PLANNING CONSULTATION RESPONSE

Application No	2025/0583
Proposal	Erection of detached two-storey dwelling with associated access and garage
Address	Land adjacent St John the Evangelist Church, Carlton Road, Carlton, Barnsley
Date of Consultation Reply	26/08/25
Consultee	Highways DC

PROJECT TITLE
CARLTON ROAD, BARNLEY

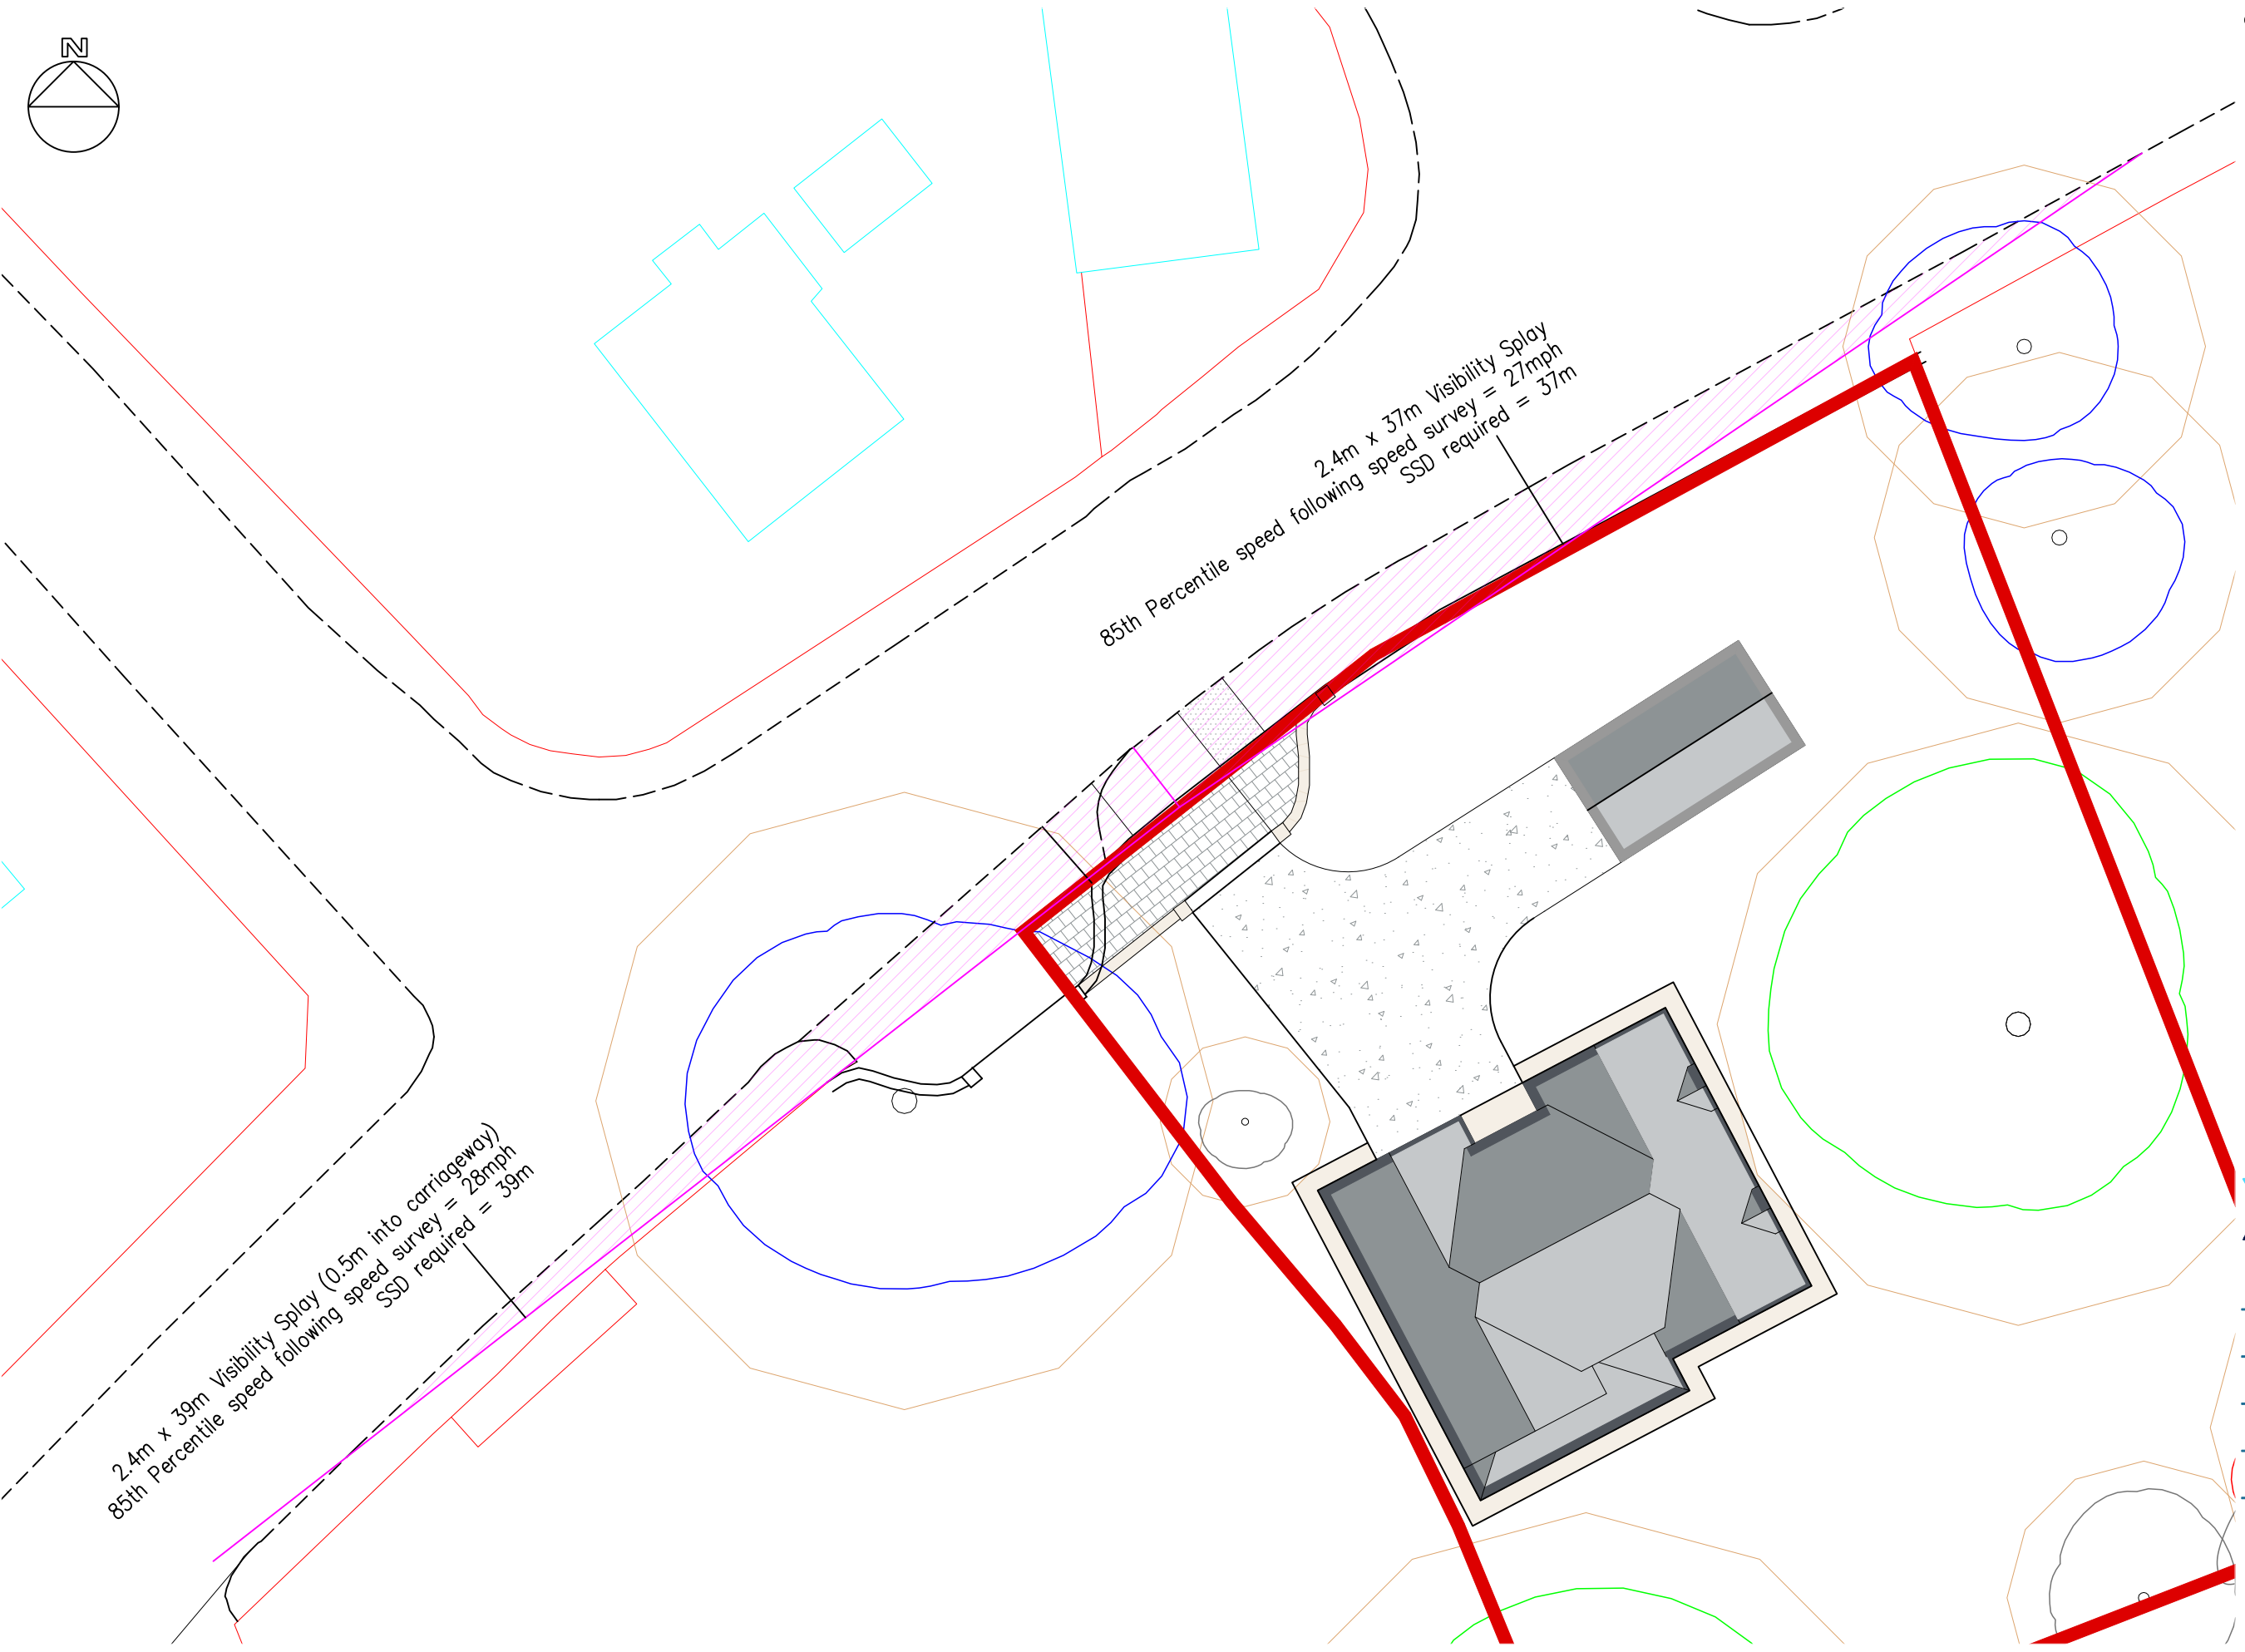
However, although visibility splays appear to have been drawn on the site plan within drawing no. 24-157-01-A, the full sight lines are not shown. As such, HDC officers would ask that visibility splays of 2.4m x 43m from the access onto Carlton Road are demonstrated on a dimensioned plan.
